Application No: R/60/22/PL
Site Address: The Windmill Inn Mill Lane Rustington BN16 3JN
Description of works: Extension and remodelling of existing public house to form hotel with 20 No bedrooms and associated parking and landscaping. This site is in CIL Zone 4 (Zero Rated) as other development.

Thank you for your internet representation made on 20th April 2022 which has been recorded as support with the comments as follows:

DRAWING TITLE
Proposed Ground & First Floor Plans

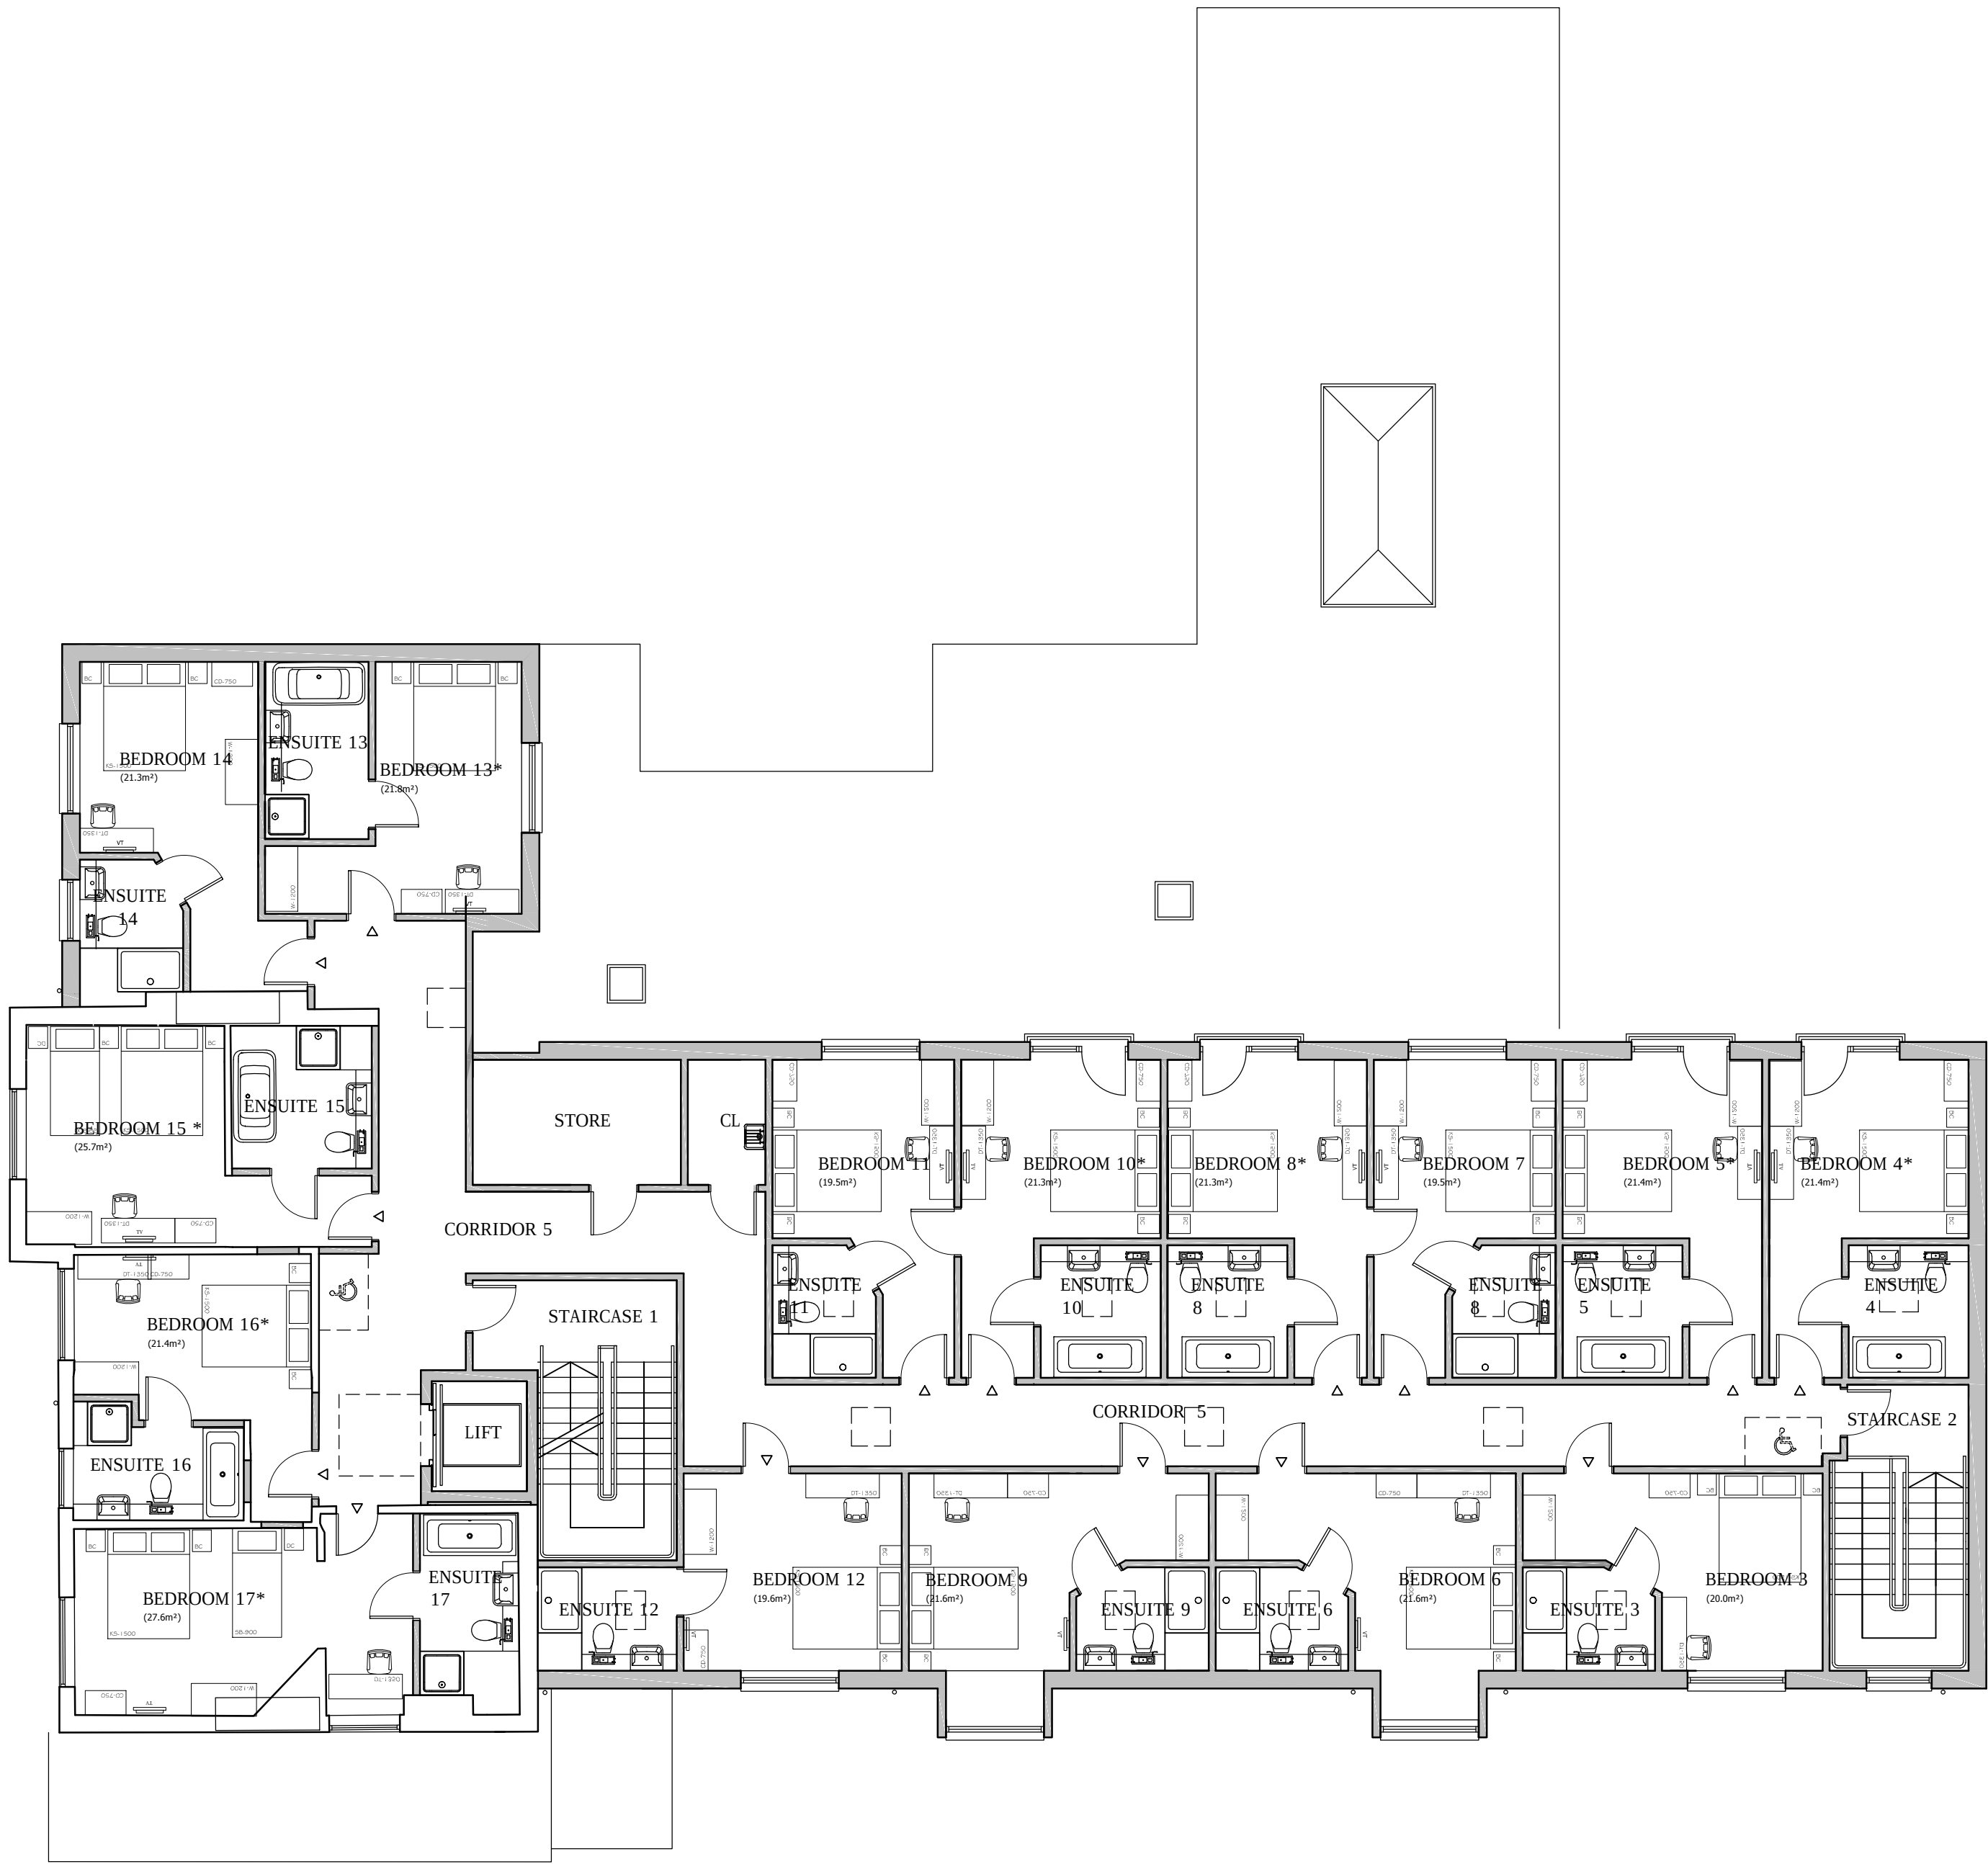
Our only concern is the north elevation which has 6 full length windows/doors looking down our garden. Maybe the light to these rooms could be via a Velux window and screen/wall on the flat roof area for our privacy. You're more than welcome to view from our garden.
